RE: YUKON & ASSOCIATES (D-17/D046), ENGINEER'S STAMP DATED 2/10/1999,  
ENGINEER'S CERTIFICATION DATED 12/8/2000.

RE: YUKON & ASSOCIATES (D-17/ D046), ENGINEER'S STAMP DATED  
2/10/99, CERTIFICATION DATED 10/10/2000.

RE: YUKON ASSOCIATES (D17/D46), 2/10/99 DRAINAGE & GRADING SUBMITTAL  
FOR BUILDING PERMIT APPROVAL. ENGINEER'S STAMP DATED 2/10/99

DRAWN BY: T.P.H. DATE: FEBRUARY, 1999
 CHECKED BY: D.A.L.
 FILE: 99502DET.DWG SHEET C-2

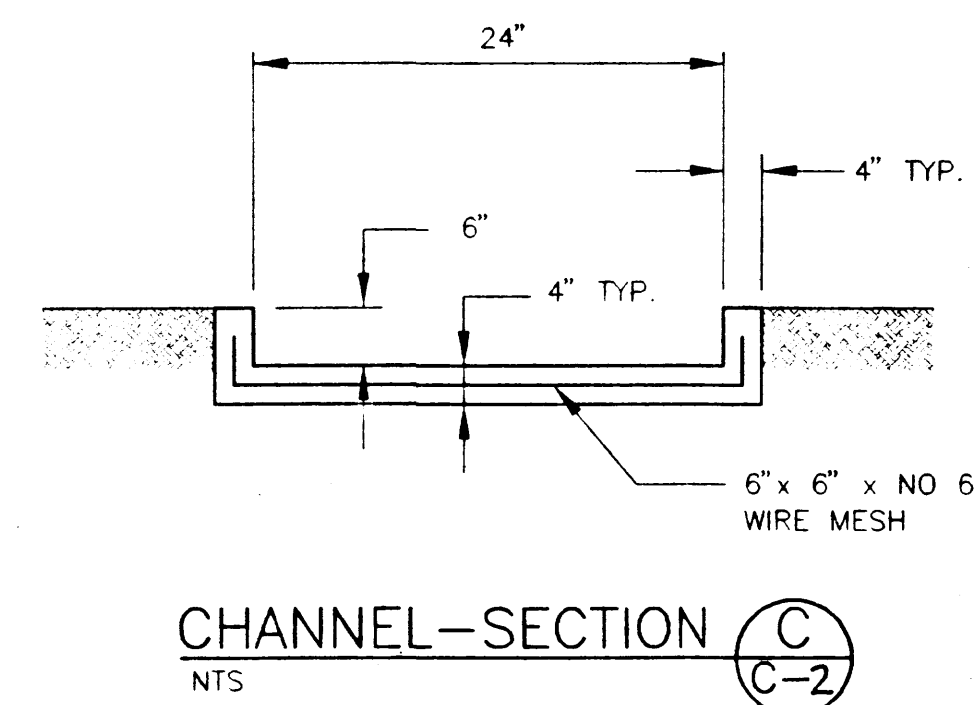
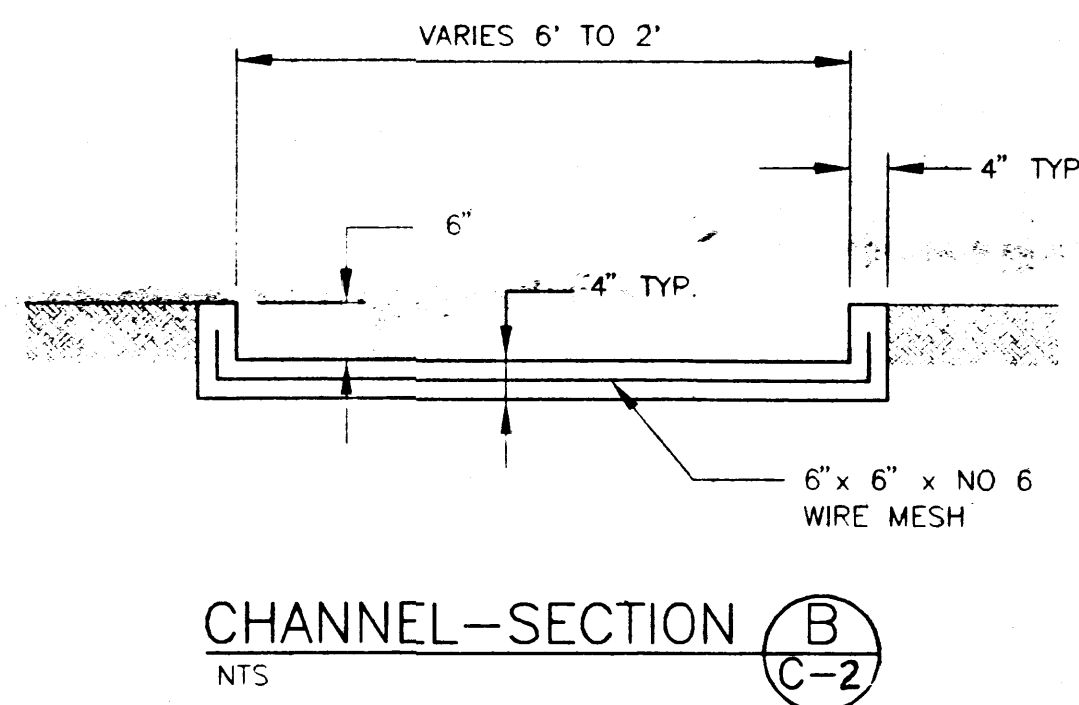
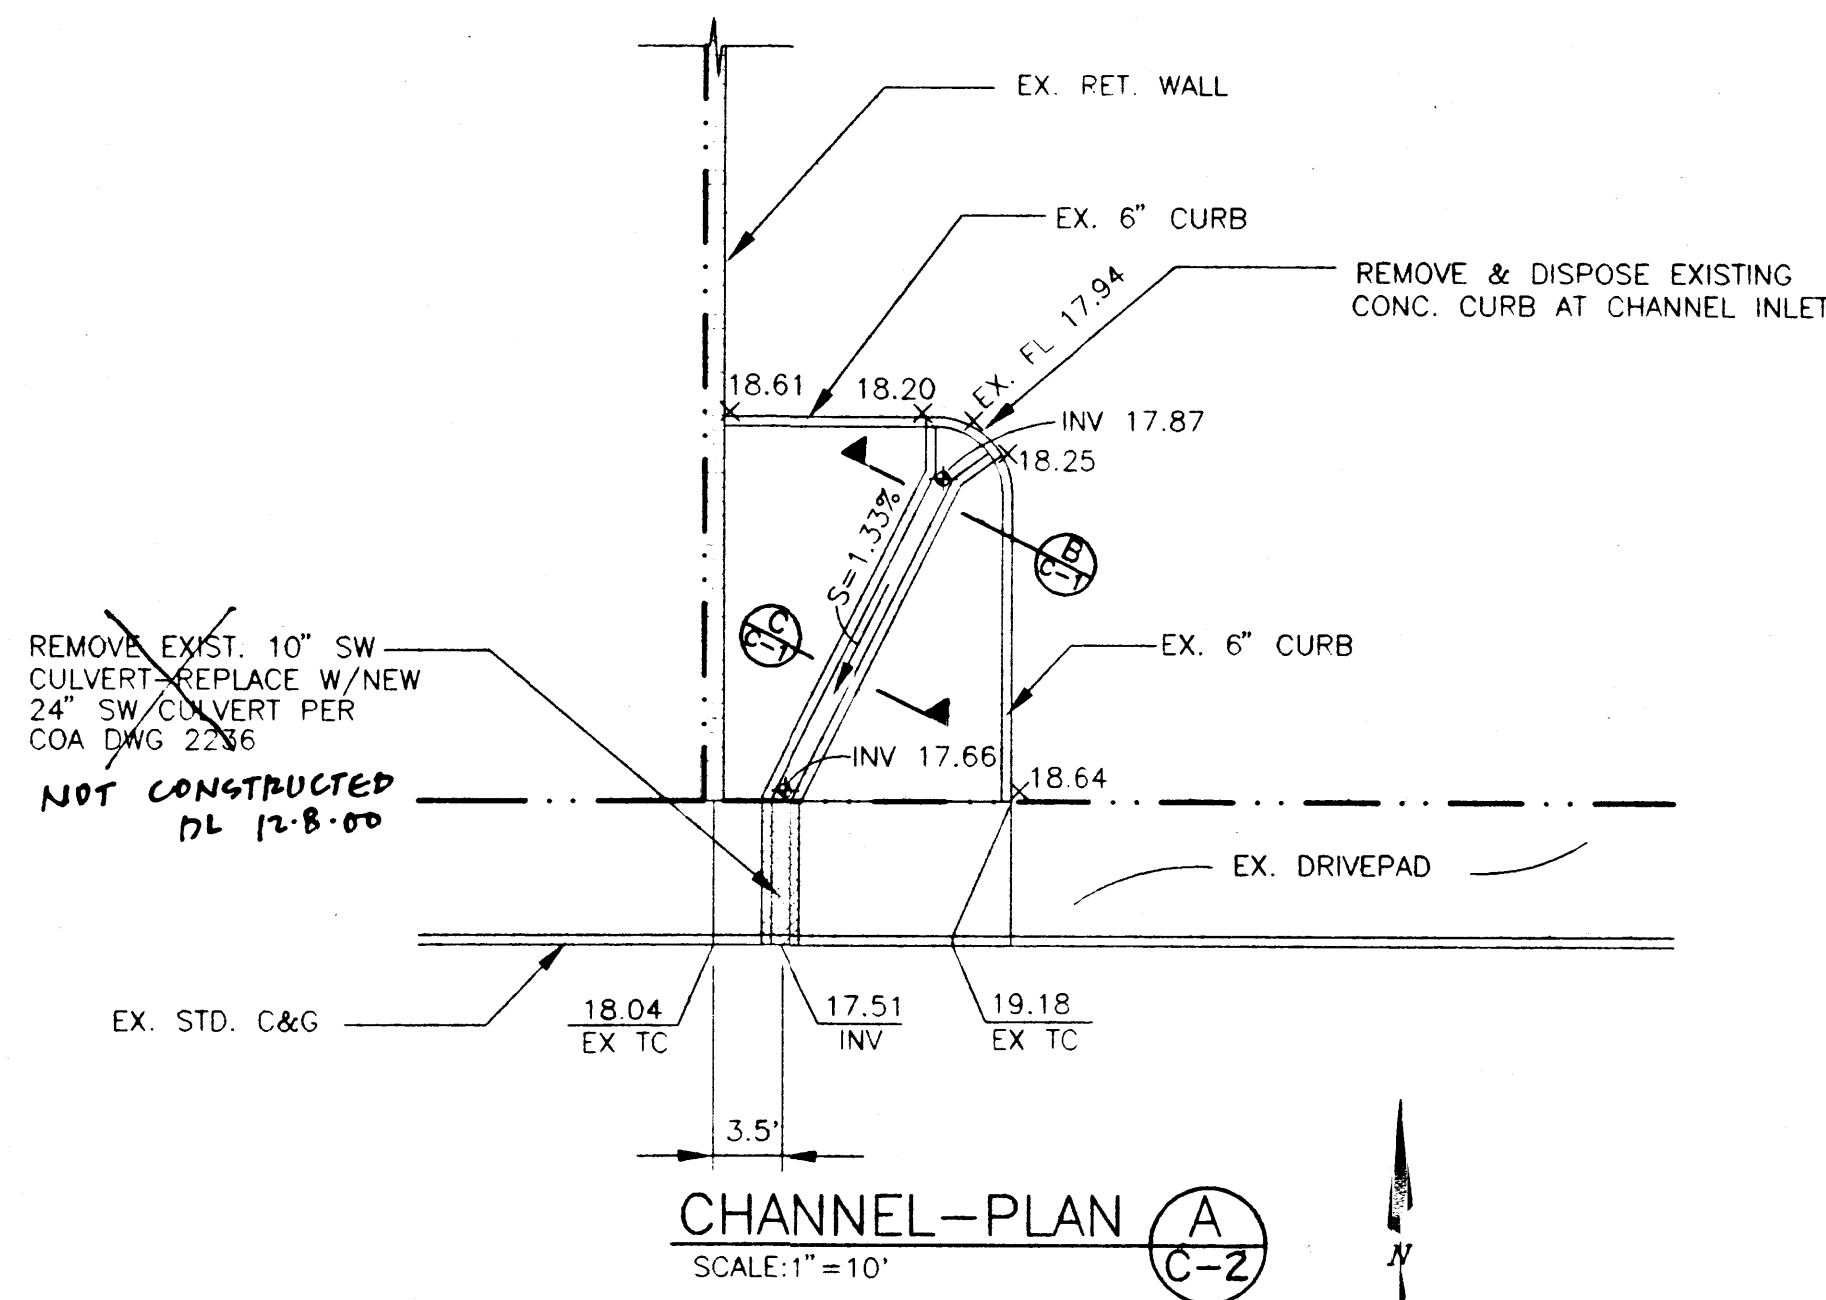
Your submittal lacks the sign-off by the City inspector for the SO 19 covering the sidewalk culvert, the signature block found on sheet C2. Please provide us with an approval at your earliest convenience so that we may sign off on the Certificate of Occupancy.
